WELWYN HATFIELD BOROUGH COUNCIL – DEVELOPMENT MANAGEMENT
DELEGATED REPORT

APPLICATION No: S6/2014/0510/FP

SITE ADDRESS: 3 Lysley Place, Brookmans Park, Hatfield

DESCRIPTION OF DEVELOPMENT: Part single and part two storey rear extension with balcony

rev:	revision notes:	date:
drawn by:	drawn date:	scale:
DF	OCT 13	1:100 @ A3
project:		
GREY GABLES, 3 LYSLEY PLACE, BROOKMANS PARK, HERTS AL9 6NZ		
client:		
MR. & MRS. P. HARGREAVES		
dwg title:		
PROPOSED ELEVATIONS		
dwg no:		rev:
1680 PL05

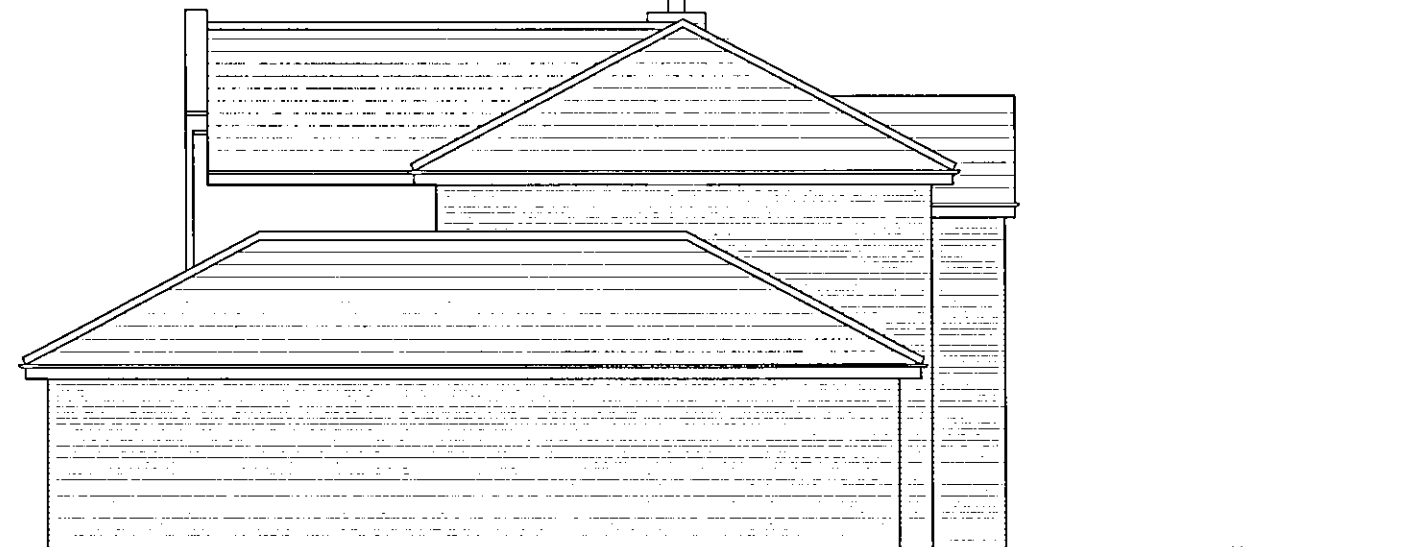
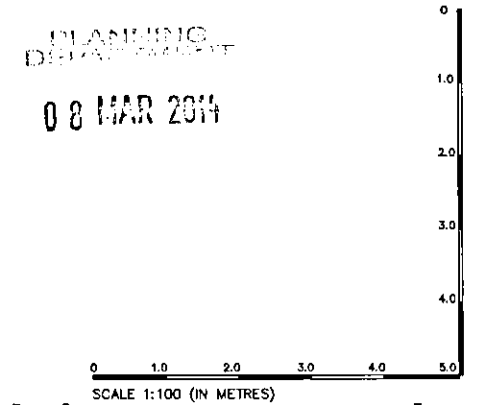
This application seeks permission for the construction of a part single and part two storey rear extension including a balcony at first floor level. The single storey aspect of the development would be built on the same footprint of an existing single storey element and would have a maximum height of 2.9m and a width of 3.7m. The two storey element of the works would have a maximum height of 7.2m, an eaves height of 5.8m, a width of 6.4m and would extend beyond the rear wall of the application property by a maximum of 3.5m. The development would be constructed of painted render and roof tiles to match the existing dwelling.

Although this is a significant percentage increase, it is not conclusive as the NPPF test is primarily an objective one based on size. This proposal would add considerable mass and bulk and would be seen as a sizable increase in volume and built development on this site. In this respect, it is also considered that the proposal would be inappropriate development.

The proposal would add mass, bulk and volume to the already extended house. The associated increases in scale, mass, bulk and volume arising from these works would represent a detrimental impact on the openness of the Green Belt. However, given the nature of the proposal, located to the rear of the dwelling, on a large site which would still remain largely undeveloped as a result of the proposed works, and the limitation of the extension within the footprint of the existing extended dwelling house, only limited weight should be afforded to this harm to the openness of the Green Belt.

Concerns have been raised regarding the overall scale of the development, which would disrupt the design and character of the existing dwelling. This is as the works, when viewed in context with the existing property, add a considerable amount of mass and bulk and are not subservient in nature. However, as discussed above, the works are to the rear of the dwelling and, therefore, views of the development from

1. The proposal represents a disproportionate addition to the original dwelling house and is therefore inappropriate development within the Green Belt. In addition, the proposal would have a detrimental impact on the openness, character and visual amenities of the Green Belt and surrounding area. The Local Planning Authority do not consider that very special circumstances exist which outweigh the harm, by reason of inappropriateness and other identified harm in the form of impacts on openness, character of the area and visual amenities of the Green Belt. The proposal is therefore contrary to the National Planning Policy Framework and policy RA3 of the Welwyn Hatfield District Plan 2005.

dwg no:	rev:
1680 PL03

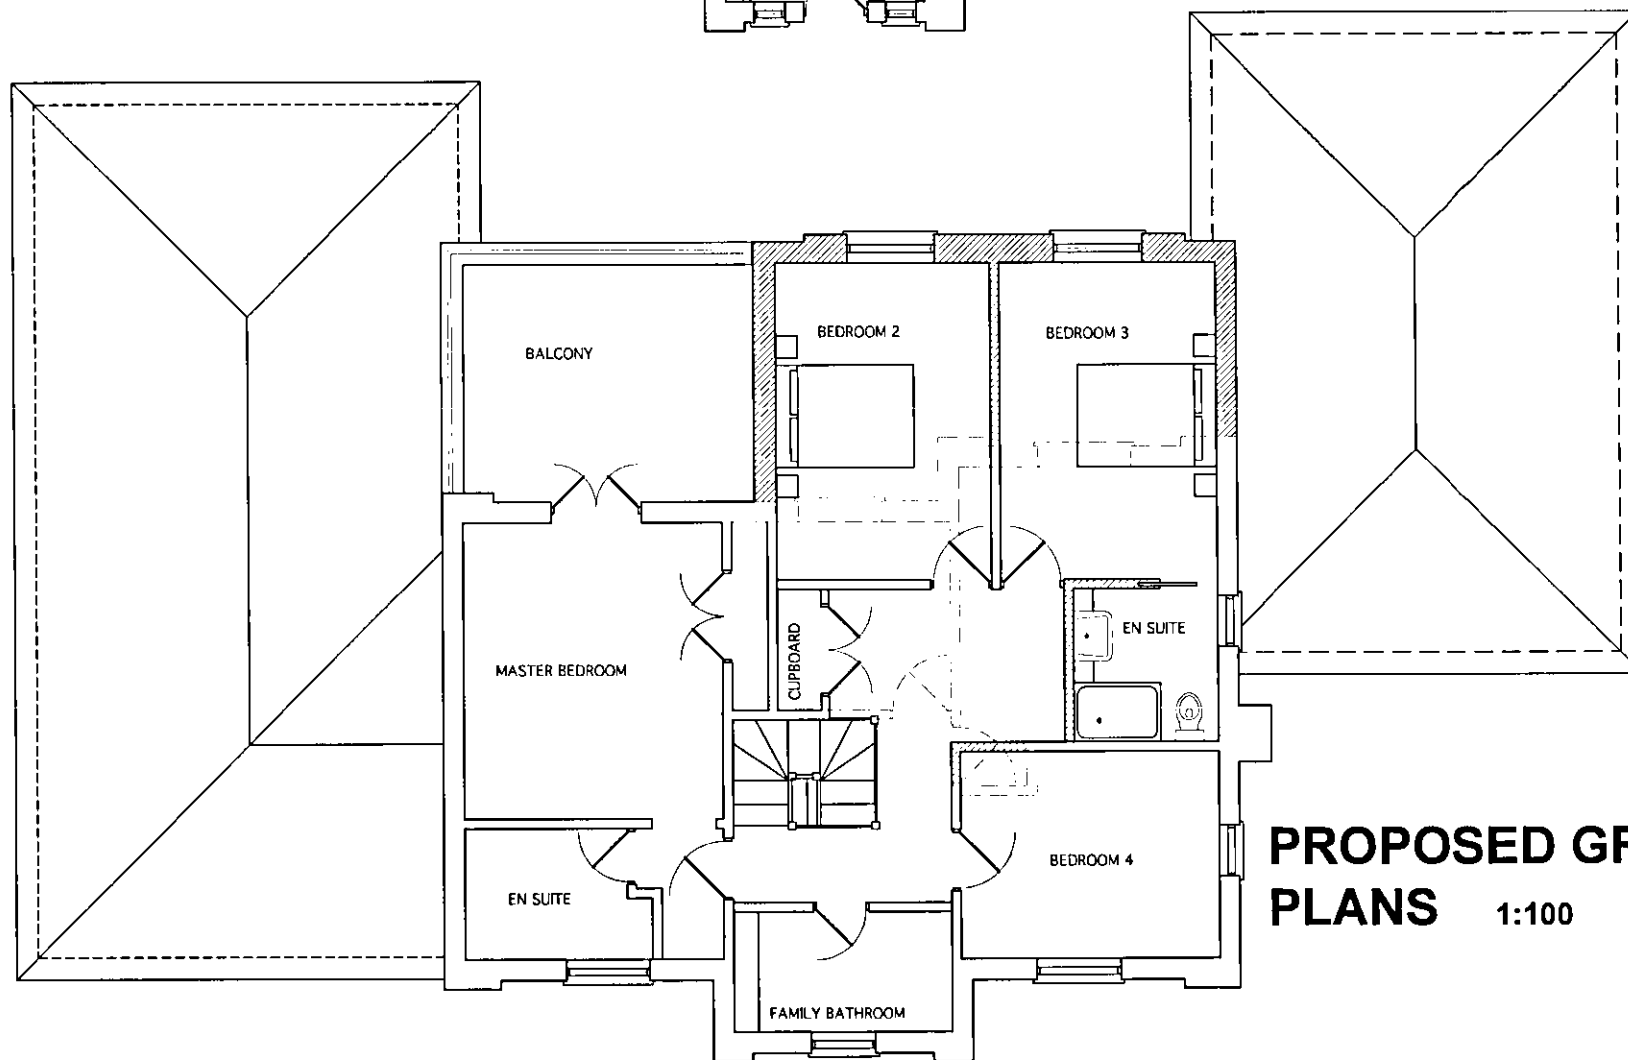
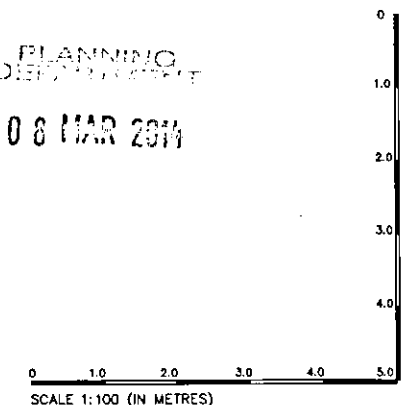
The floorspace of the original dwelling has been calculated to be approximately 176.2m². The existing dwelling has been previously extended which has increased the size of the existing property to 257.6m². At present, the floorspace of the application property has been increased by approximately 46% when compared to the original dwelling. The current proposal would increase the overall floorspace of the dwelling to approximately 297m² and would equate to approximately a 69% increase to the size of the original dwelling. This is considered to amount to be a disproportionate increase to the size of the original dwelling

Accordingly, the proposal is considered to represent a disproportionate addition over and above the size of the original building and is therefore contrary to the NPPF and Policy RA3 (i) of the District Plan in this regard. This harm carries substantial weight as set out in the NPPF (para.88).

As part of good practice the 45 degree line test has been considered from neighbouring dwellings. This line test is not contravened by the proposed development. Having regard to this, and also to the orientation of the application property, it is considered that the development would not detrimentally impact on the amenity of neighbouring dwellings, in terms of overshadowing and overbearing. Furthermore, the location of proposed first floor windows would not provide views of primary amenity space, which is located closer to neighbouring dwellings. In addition, views of primary amenity space from the proposed first floor balcony would be restricted. On this basis, it is judged that neighbouring privacy would be preserved.
